Application no: **3/2021/1065**

Address: **Riverside Lodge Sawley Old Brow Sawley BB7 4LF**

Proposal: **Proposed car port and store room to existing greenhouse and potting shed.**

PROPOSED PLAN

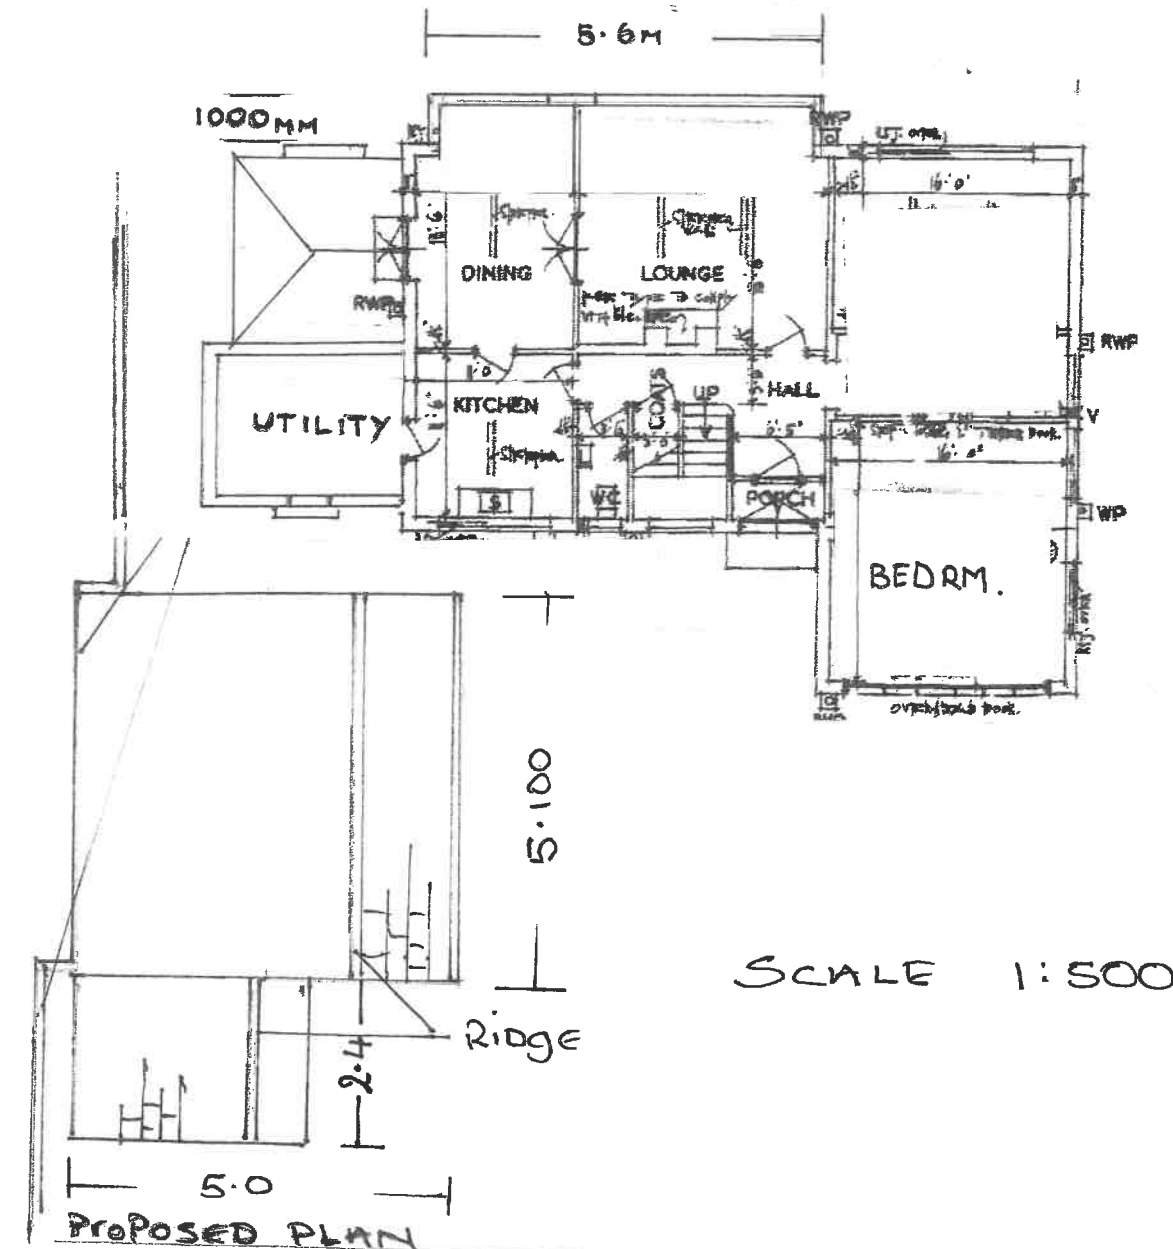
The LHA have reviewed the drawing titled "Proposed Plan" and understands that the proposed garage will have the dimensions of 5.1m x 5m.

The LHA have no objection to the proposal with the parking arrangements at the site being a pre-existing situation on a private, unadopted road. However, the LHA would advise the Applicant that should the garage be used for a parking space, the internal dimensions should be a minimum of 6m x 3m and for two spaces 6m x 6m.
